RE: Fred Loya Insurance
7376 McLaughlin Road, Suite J
Falcon, CO 80831

The intent of this letter is for Change of Use from **A+ Tobacco (Mercantile)** to Fred Loya Insurance **(Business)**. Allow this letter to serve as our supporting documentation for the site information requested.

1 SITE PLAN  
 SCALE: 1" = 50'-0"

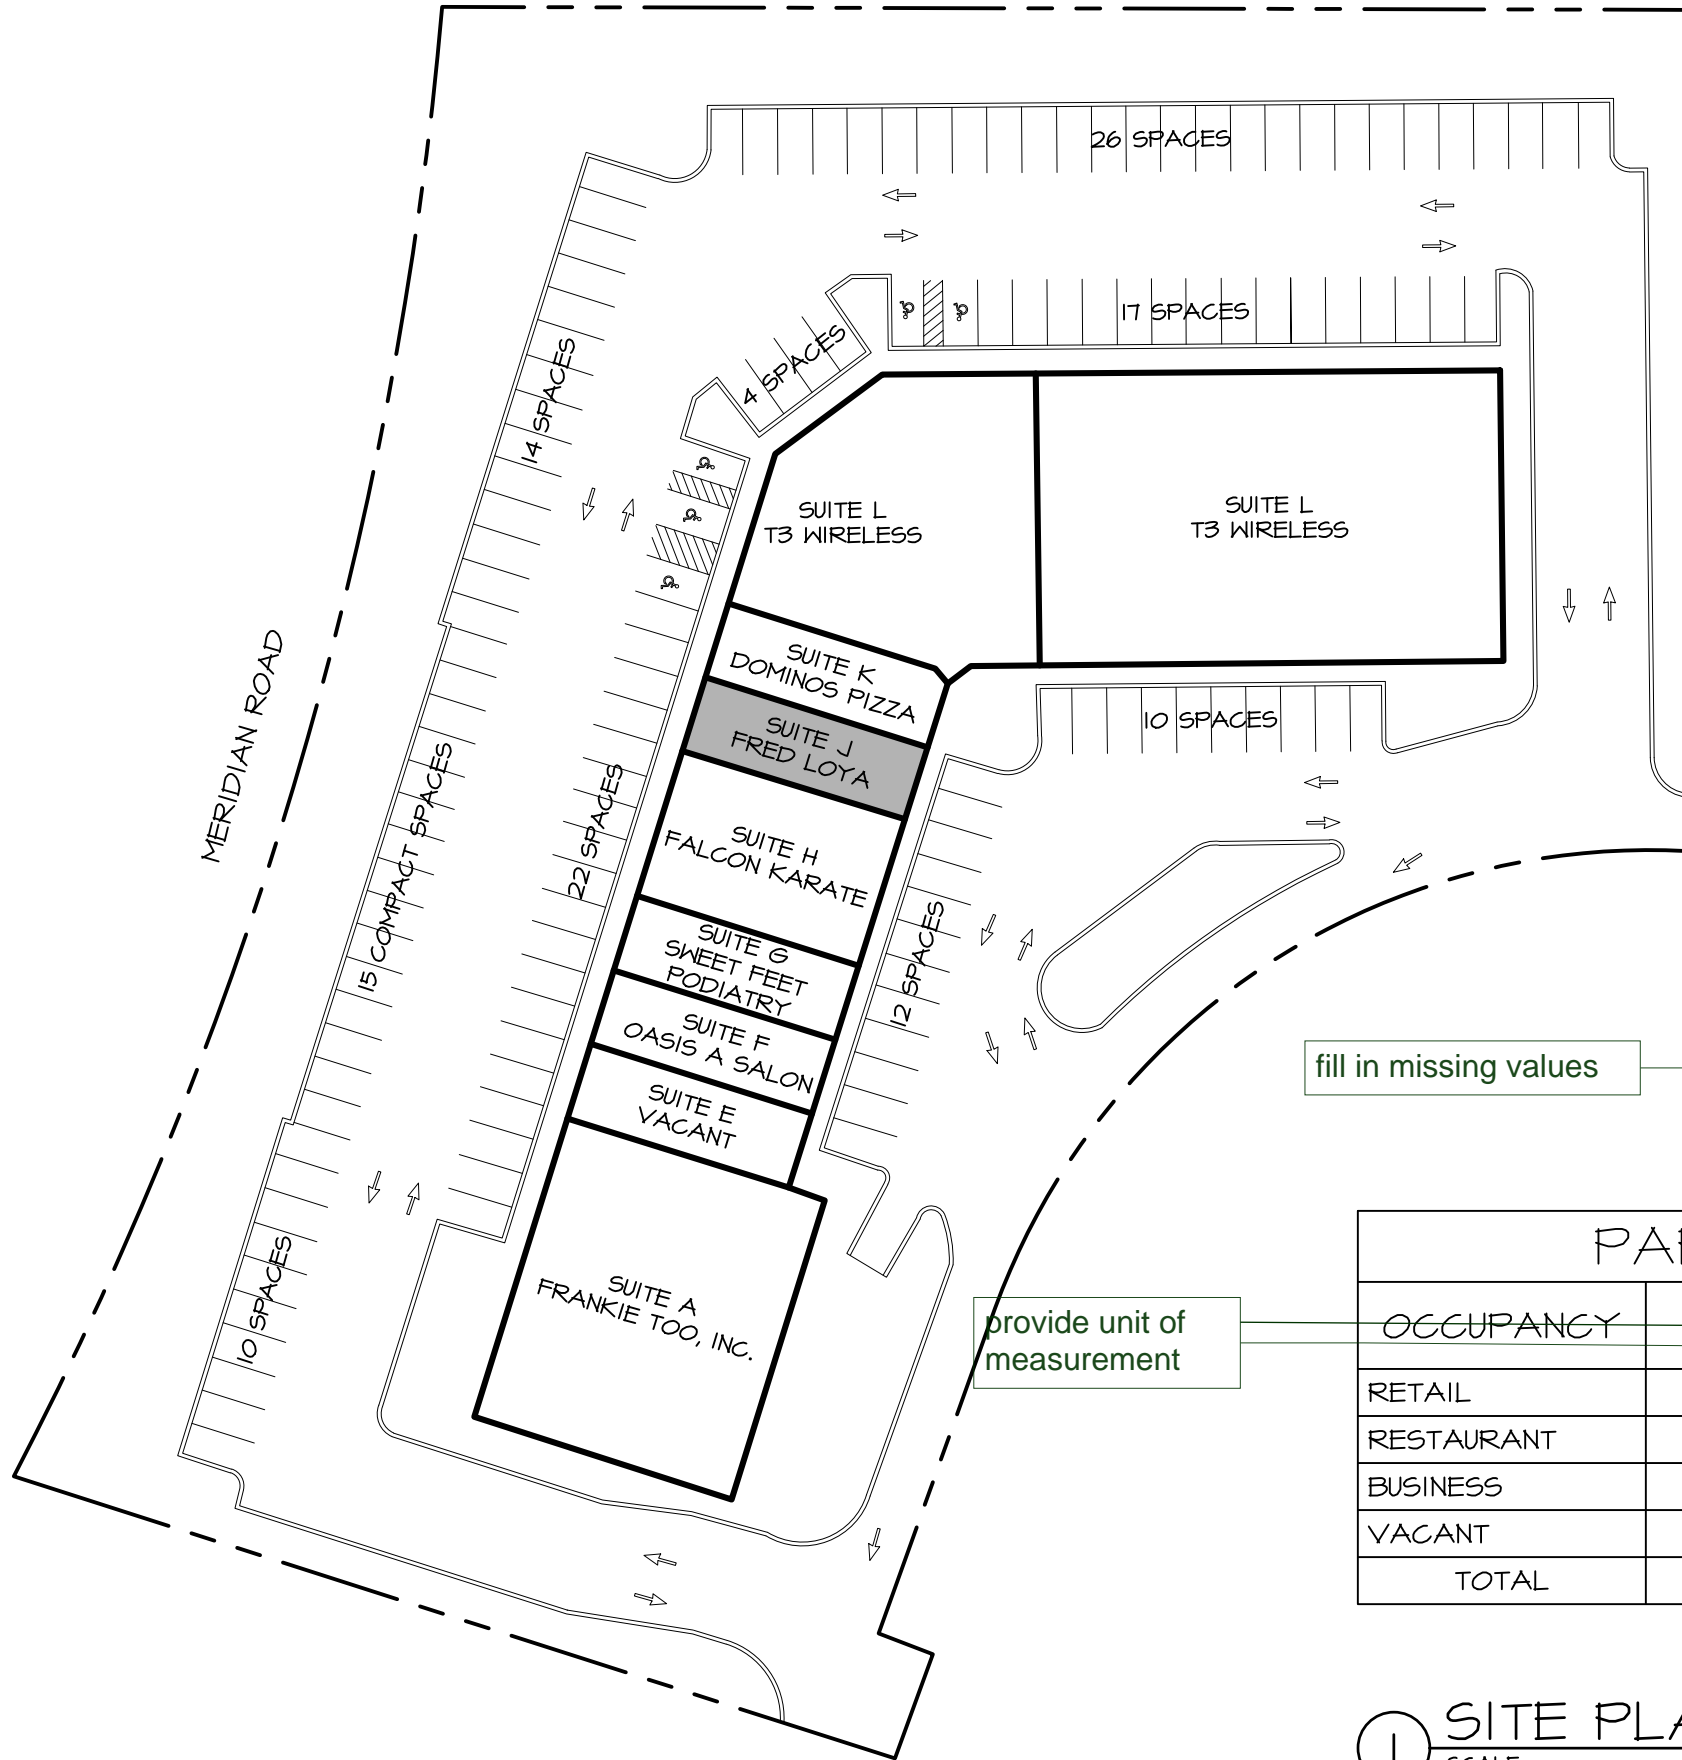
Please use names of use type from
"Table 5-1. - Principal Uses" of the LDC

The Change of Use does not affect the Traffic Impact due to the Minimum Parking Requirement by Use per Table 6-2, Commercial Centers of Less Than 10 acres, the Minimum Number of Parking Spaces is 1 per 250 square feet. This would not affect the Engineering Criteria Manual Appendix B Section B1.2.C and B.1.2.D due to no increase or decrease in traffic.

Per Google Maps image, dated 2021, the Commercial Center has a total of 131 existing parking spaces which exceeds the requirement of 1 per 250 sf (111) for centers of less than 10 acres. There are 14 existing trees that meet or exceed the required tree of a type suitable for parking lots shall be provided for every 15 parking spaces in parking lots with 15 or more parking spaces. Existing light pole fixtures are concealed and do not exceed the required 90 degree cut off angle and not 10' in height. Existing wall mounted fixtures do not have an upward lighting.
